**RE: d'Albora Marinas – The Spit Marina – MP08_0046
Application to Modify Conditions of Consent**

We attach copies of Corben Architects drawing DA01 rev R, being the approved stamped plan and Corben Architects drawing DA01 rev W, showing the proposed modifications.

MPO80046 MODIFIED PLAN DA01/W

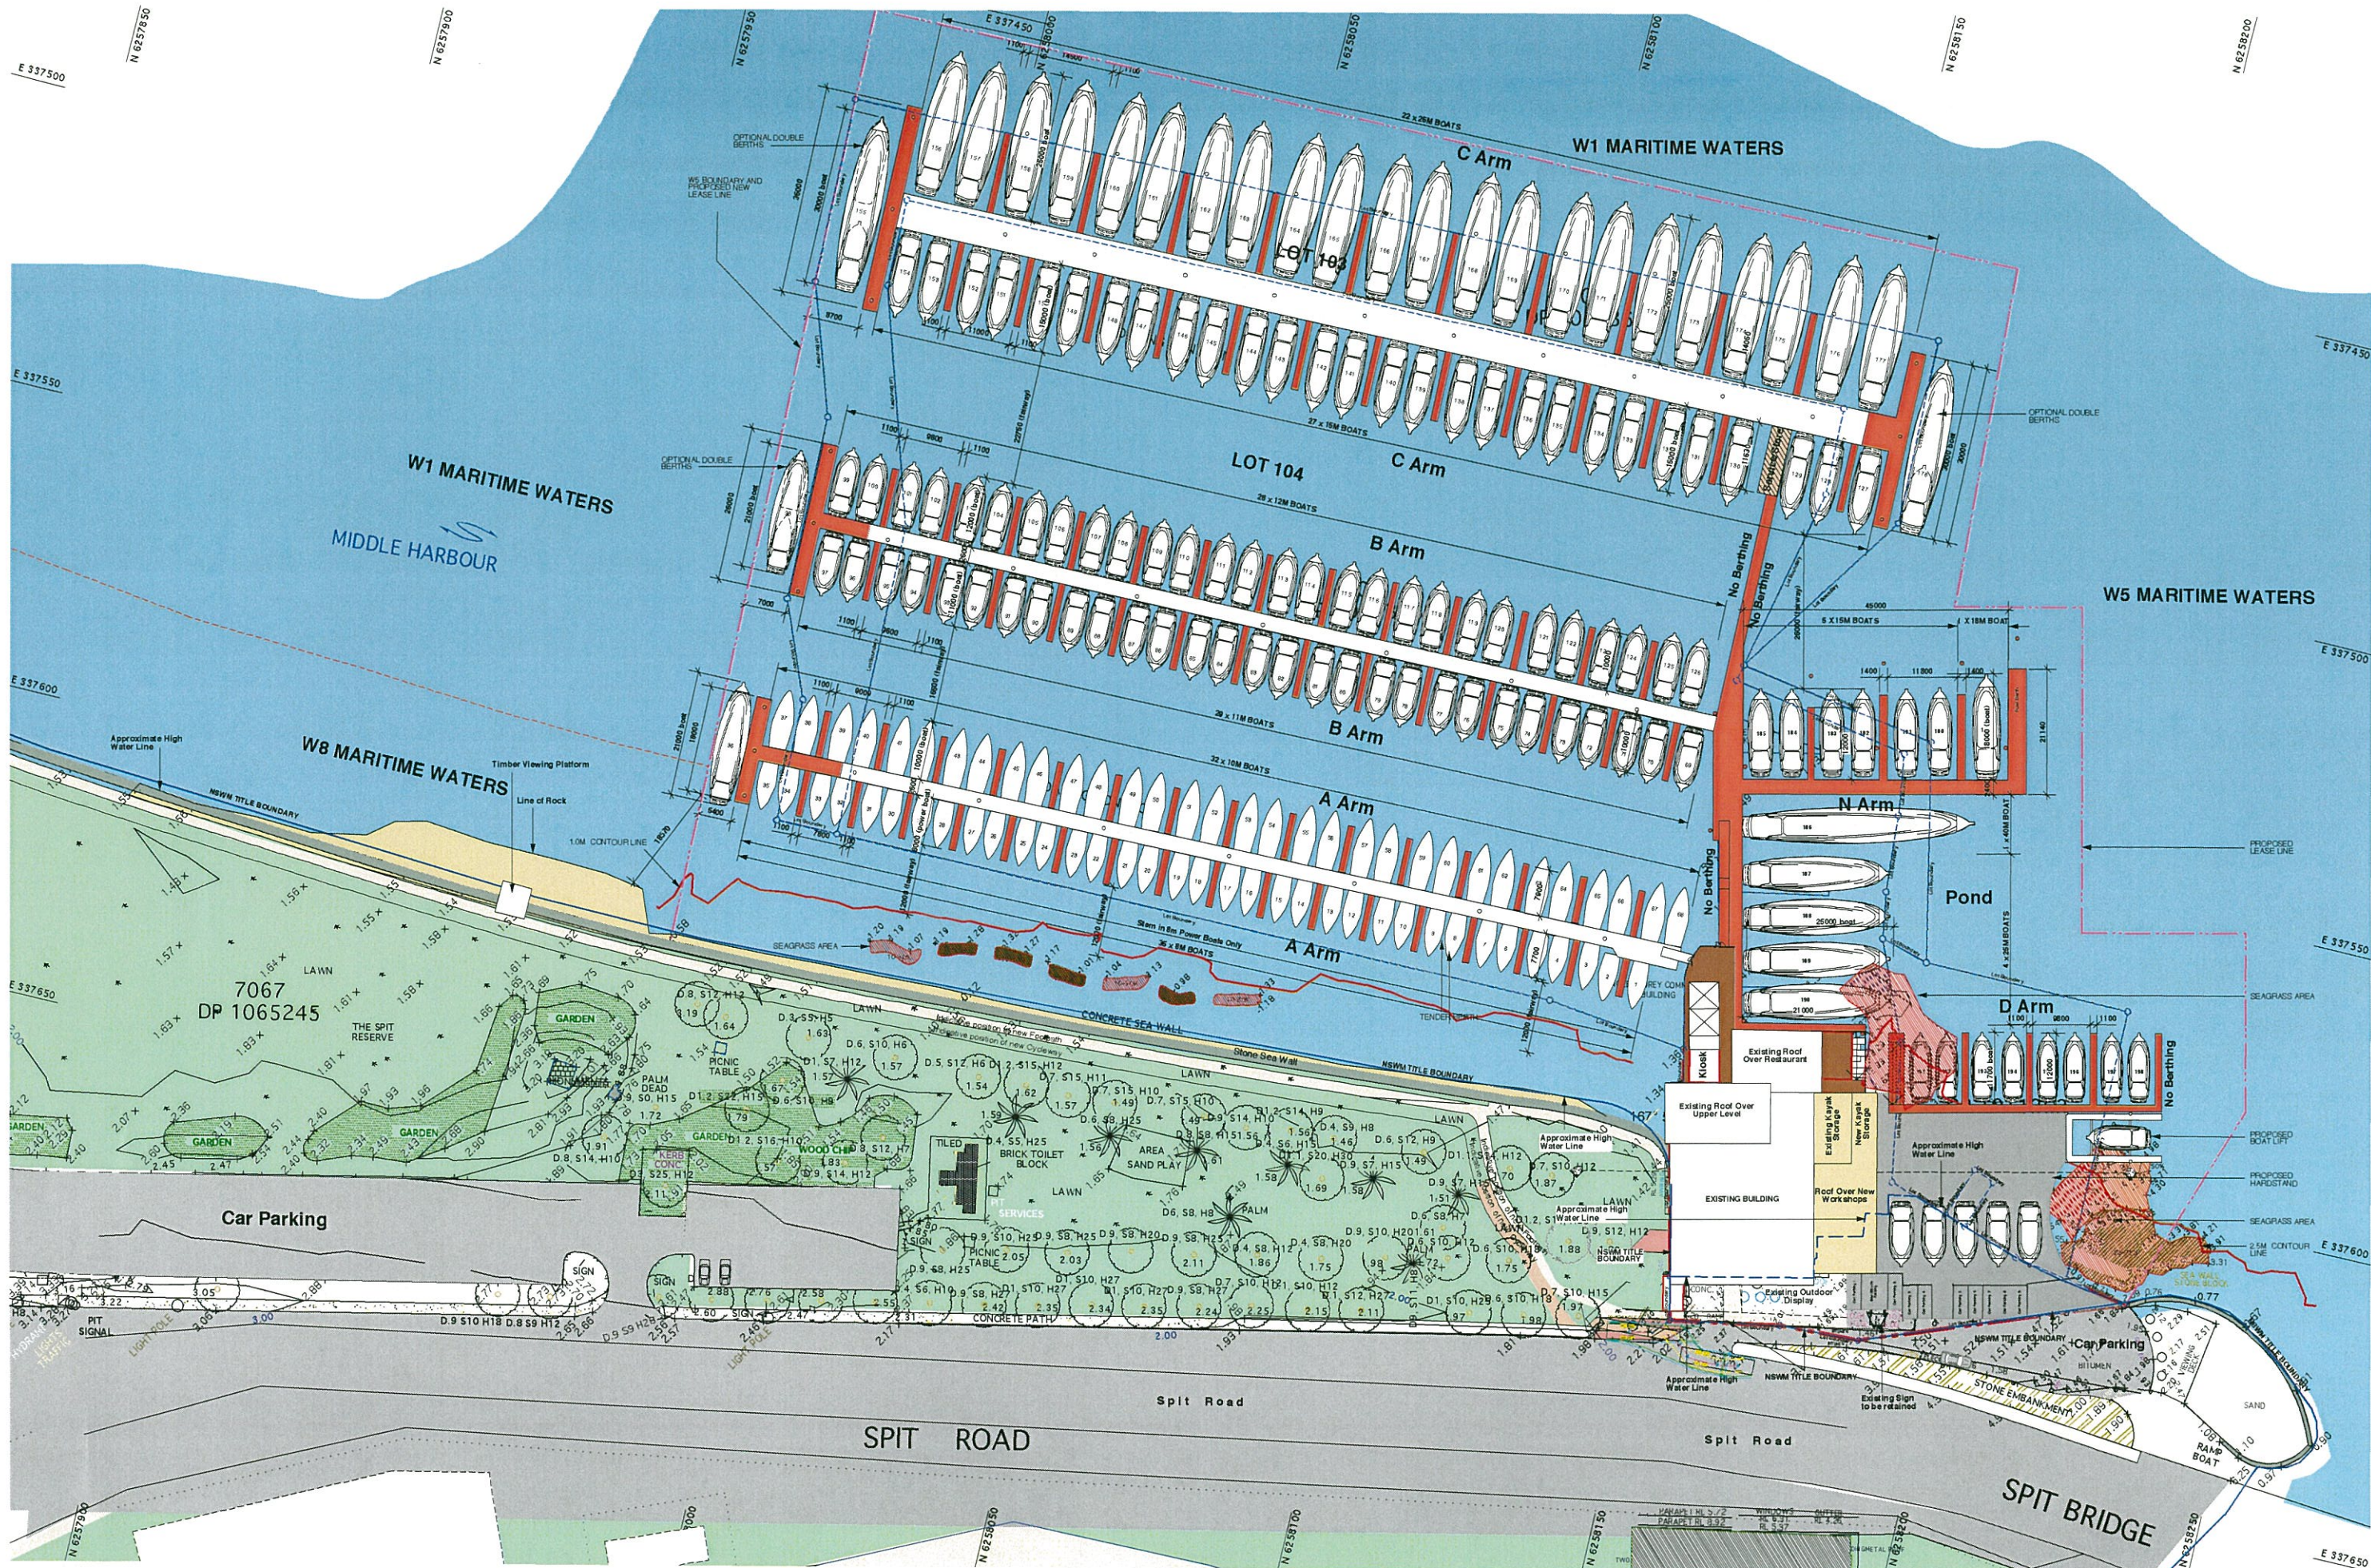
1. Relocation of the approved fuel dock to N Arm with reconfigured berthing.

The existing fuel dock is located on the raised N Arm timber wharf structure. The aged timber wharf is in need of substantial structural works and it is considered beneficial that the replacement of the timber wharf with new floating pontoons be constructed now.

To accommodate the relocated fuel dock will require a reconfiguration of berthing arrangements on N Arm, we note that there is no change to the approved berthing numbers in making this minor change.

2. Relocation of existing floating walkway connecting C Arm

This proposal is to relocate the connecting walkway to provide a direct lineal access from N Arm to C Arm.

3. Floating berthing finger to end of D Arm

In relocating the fuel dock to N Arm the proposal includes for the replacement of a fuel dock pontoon with a floating berthing finger on D Arm.

We note that as part of RMS Maritime's assessment for the Permission to Lodge for this application, a condition that No Berthing be permitted on the outside of the proposed end floating berthing finger on D Arm.

This reconfiguration requires no change to the approved berthing numbers.
